TECHNICAL REVIEW – VISUAL ASSESSMENT (SSD-5765)

Project:	N4006_001 Bowdens Silver Visual Radial Analysis	Date:	18 August 2021
To:	Lue Action Group	From:	Rod Williams
ATT:	Phil English	CC:	Click or tap here to enter text.
Subject:	Visual Radial Analysis – Proposed Transmission Line

Figure 1 Potential Visual Catchments (Source Richard Lamb 2020)

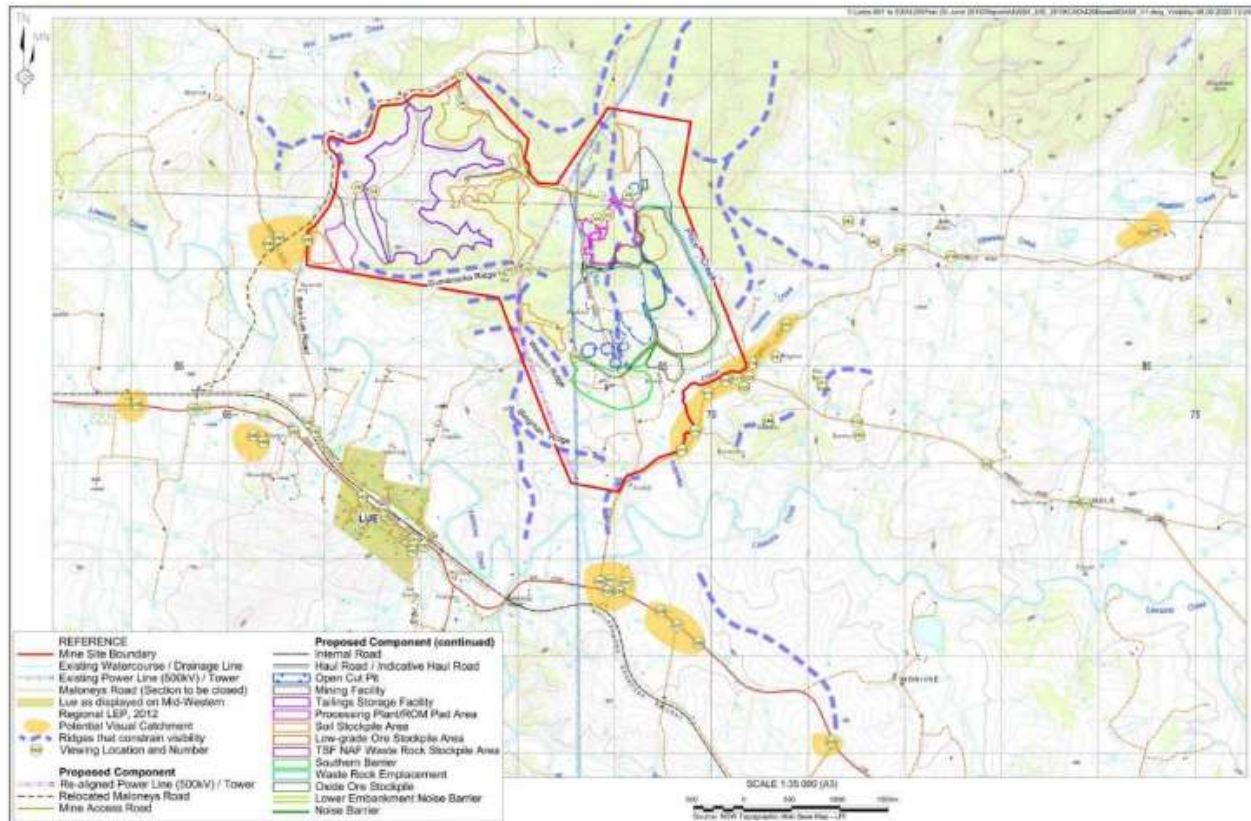
The village of Lue is located to the southern west of the proposed mine and the re-aligned power transmission line. Views from the Lue general area to the Northeast (i.e. towards the existing power transmission line) are completely screened by the existing natural topography (see Figure 1). Three cross sections from Lue to the existing transmission line alignment confirm that the views from Lue towards the Northeast are screened by the natural topography (see Figure 2, Figure 3 and Figure 4).

Figure 2 Tower 1 Cross Section

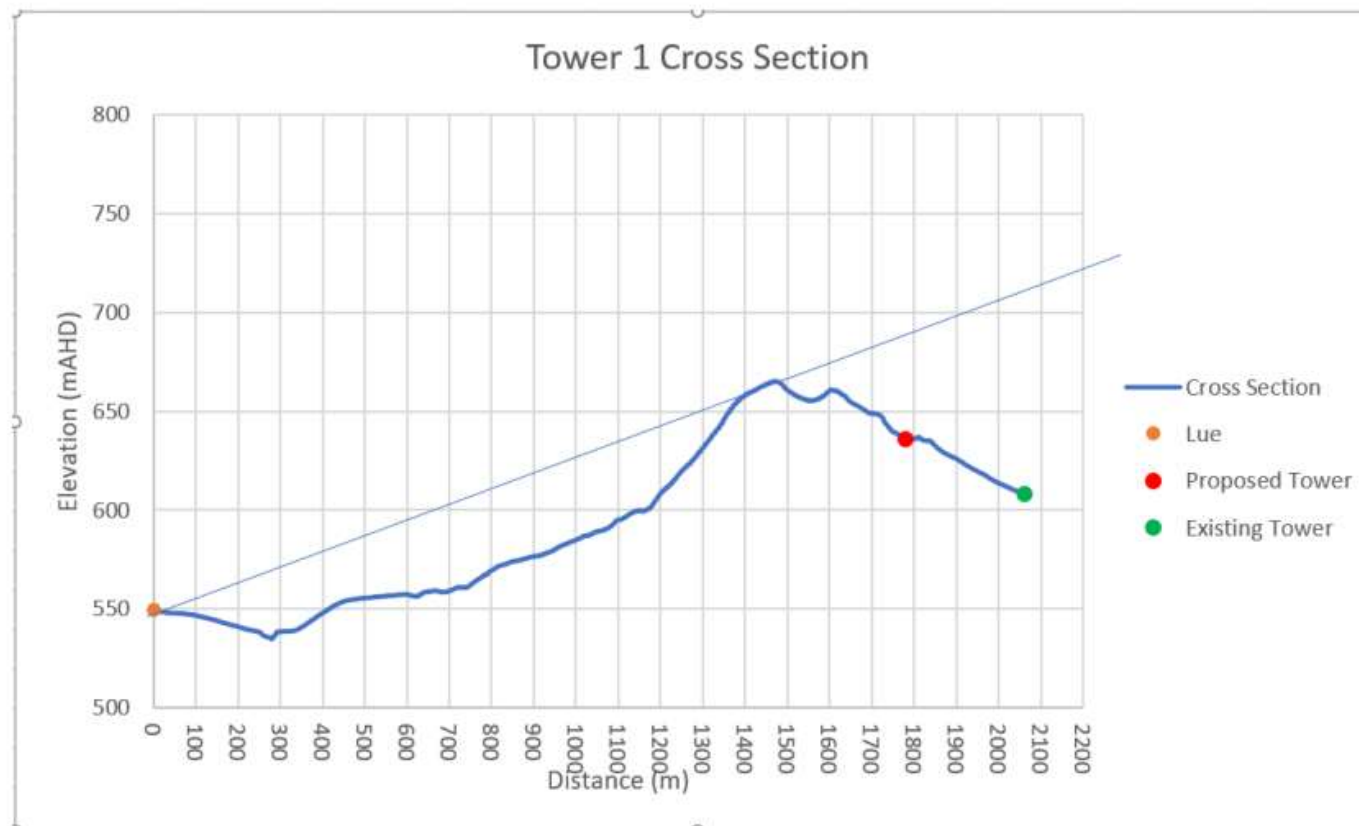
Radial analysis of three tower locations (assuming a tower height of 60m and a viewshed of 5 kilometres from the tower) along the re-aligned power transmission line alignment has been undertaken to assess the extent to which the proposed towers will be visible from the general area of Lue (see Figure 5, Figure 6 and Figure 7). The Tower 1 radial analysis (see Figure 5) and cross section (see Figure 2) indicates that the top portion of Tower 1 will be visible from the Lue general area. However, this assumes that there is no screening provided by the existing vegetation, which is not the case. As such Tower 1 is unlikely to be

Figure 3 Tower 2 Cross Section

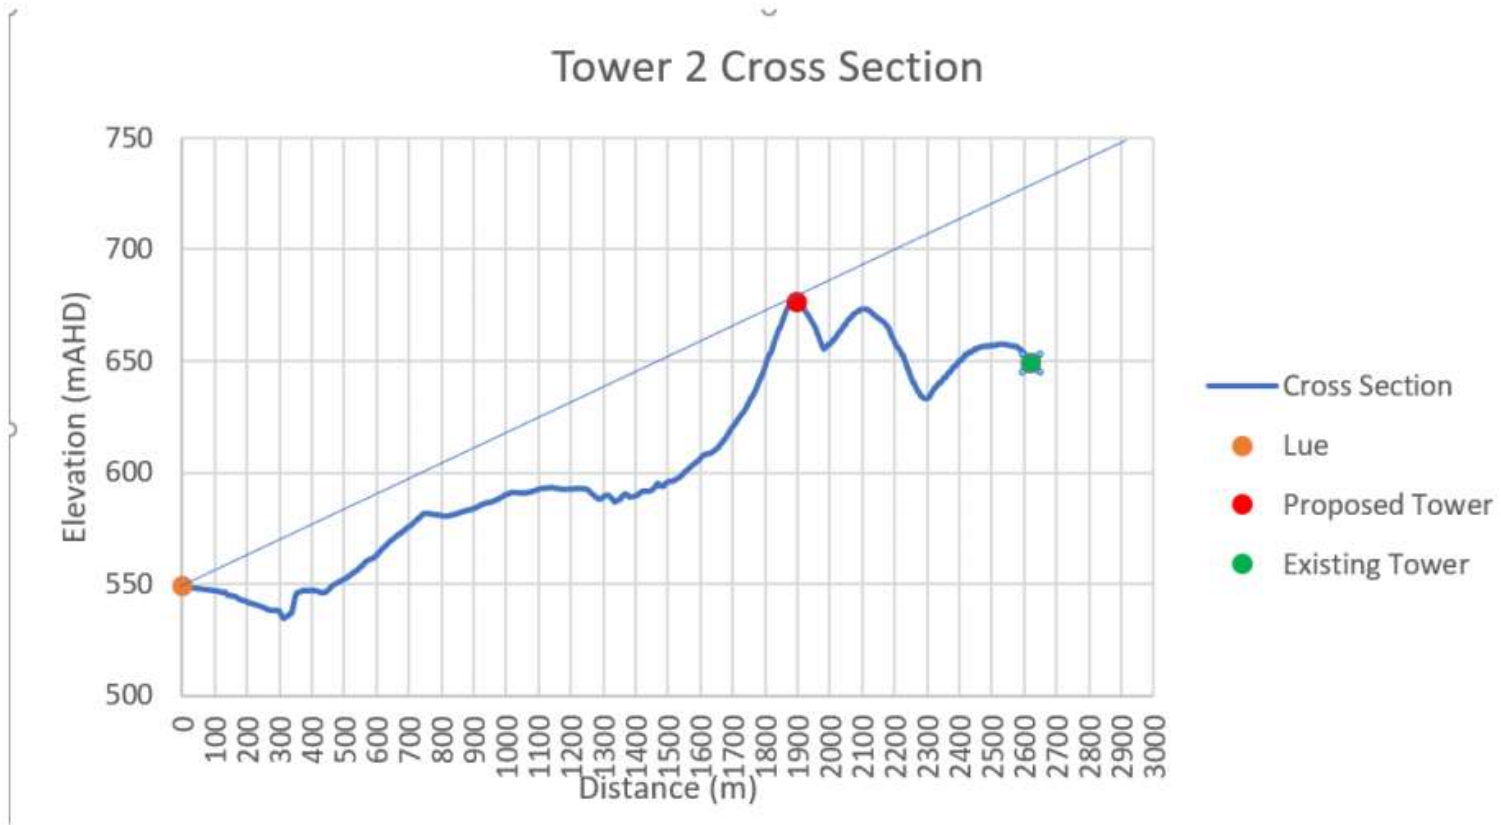
visible from the Lue general area. Towers 2 and 3 are however located on the top of the ridgeline (see Figure 3 and belowFigure 4) and as such will be clearly visible from the Lue Village and surround area (see Figure 6 and Figure 7). The visibility of the proposed power transmission line alignment would be further increased by the clearance of vegetation within the powerline easement. The extent of vegetation clearance required has not been defined in any of the documents reviewed or the contribution to the visual impact assessed.

Figure 6 Tower 2 Radial Analysis

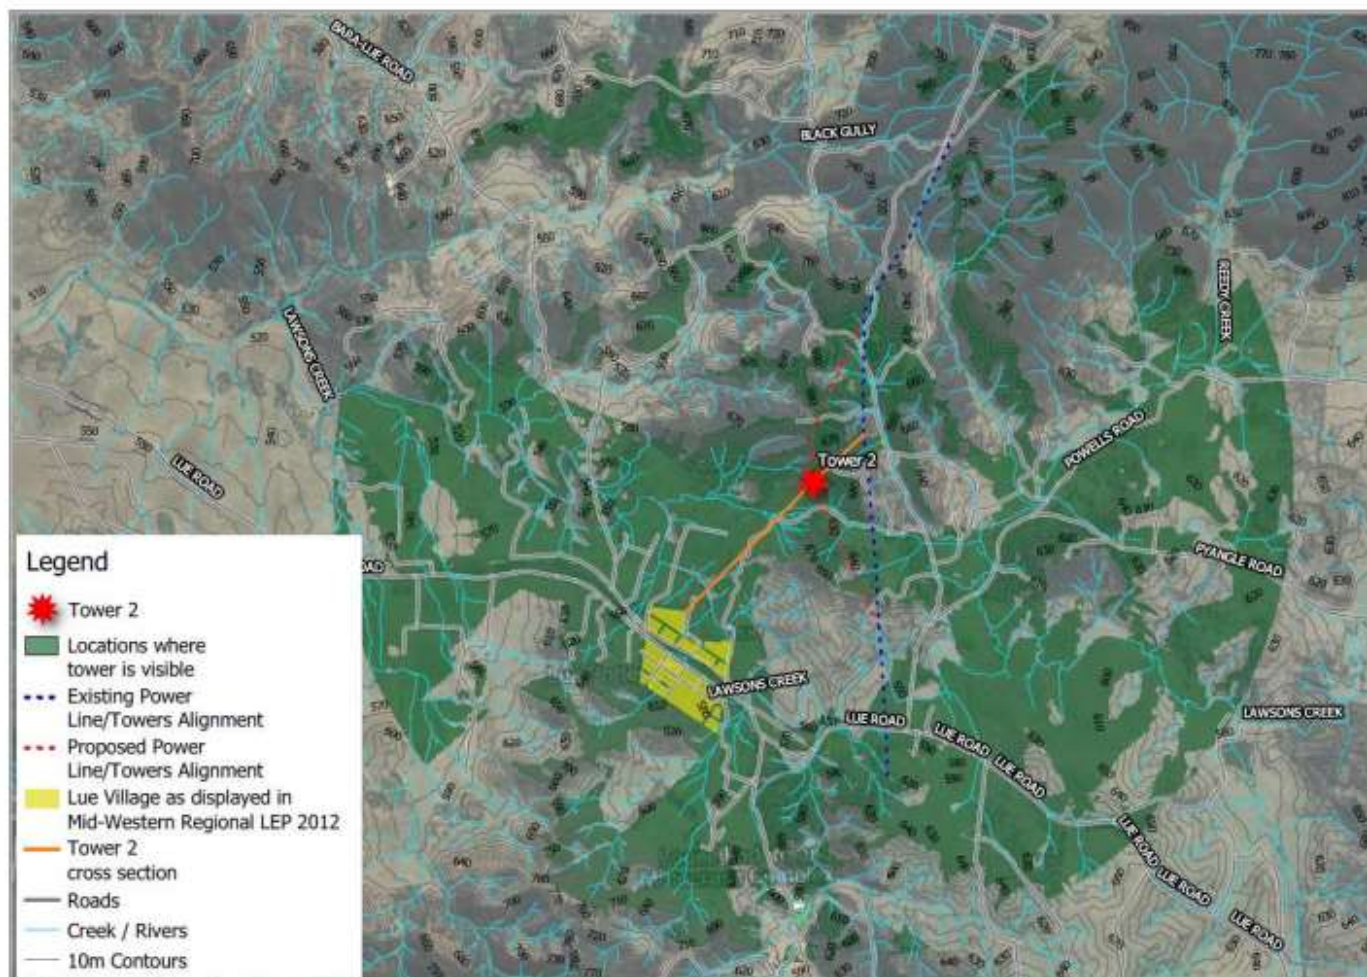
Based on this analysis it is expected that approximately 50% of the proposed re-aligned power transmission line will be clearly visible from the vast majority if not all receivers in the Lue Village and surrounding area. This represents a significant change the viewshed characteristics for the Lue Village and surrounding receivers, compared to the current situation.
